State Street Church
Second Floor

Jeanie Bourke - Re: 159 State St., BP#2014-02869 plan review comments

We, The Children's Nursery School, are asking to change the use of the State Street Congregational Church/United Church of Christ at 159 State Street (045-A-006) to include hosting a nursery school.

159 State Street Church
Second Floor

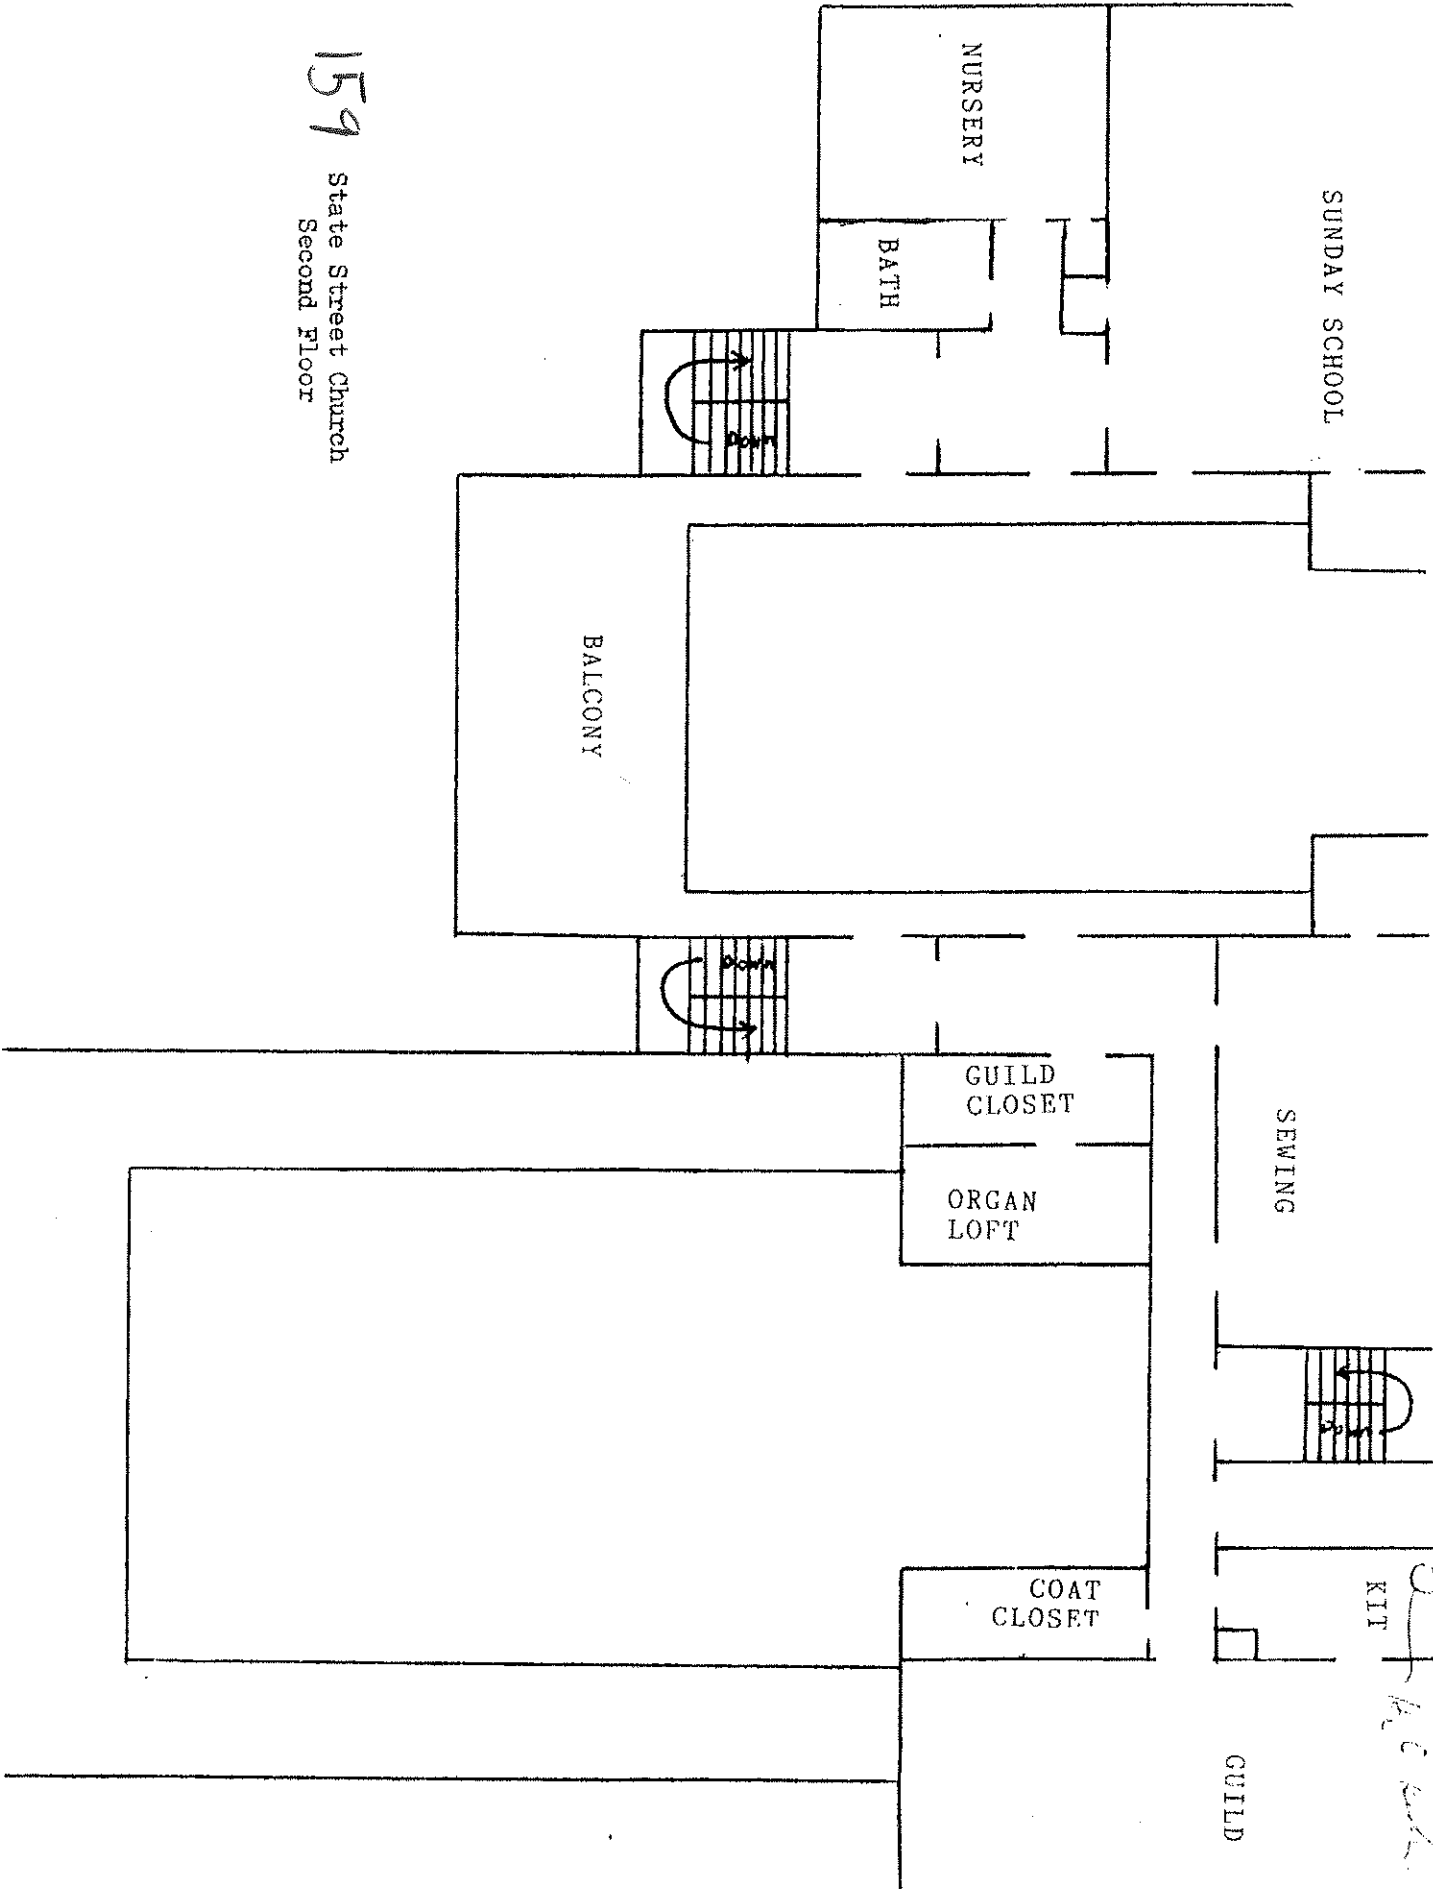
1. Does the building have a sprinkler and fire alarm system?
2. In looking at the 2nd floor plan, it appears the classroom is 702 SF. By code this room calculates to occupant load of 35. What is the typical enrollment for the school? There is another room that is not shaded pink (S.S), 340 SF, is this part of the school, either offices or classroom?
3. Please confirm if there is an exterior stair or fire escape from the classroom. It appears there is on the left side of the plan.

The room adjacent to the highlighted area is not part of our rental. The Church uses it on the weekends. We cap enrollment at 18 (we have 16 right now) and we have 4 adults in the room at all times for a total of 22 possible people.

We just underwent an inspection from a state fire inspector for our license (Ronald Peaslee [207-626-3880](tel:207-626-3880)). We passed inspection under the condition that the room aforementioned (not highlighted and not part of our school) be equipped with a fire alarm. The church has contacted an electrician and it will be done by March 6th.

We do have an external fire escape (as shown on the map) and it was approved for use by the inspector.

Finally, the church does have a fire alarm system, yet the sprinkler system is only present in the boiler room and above their ovens in the first floor kitchen.
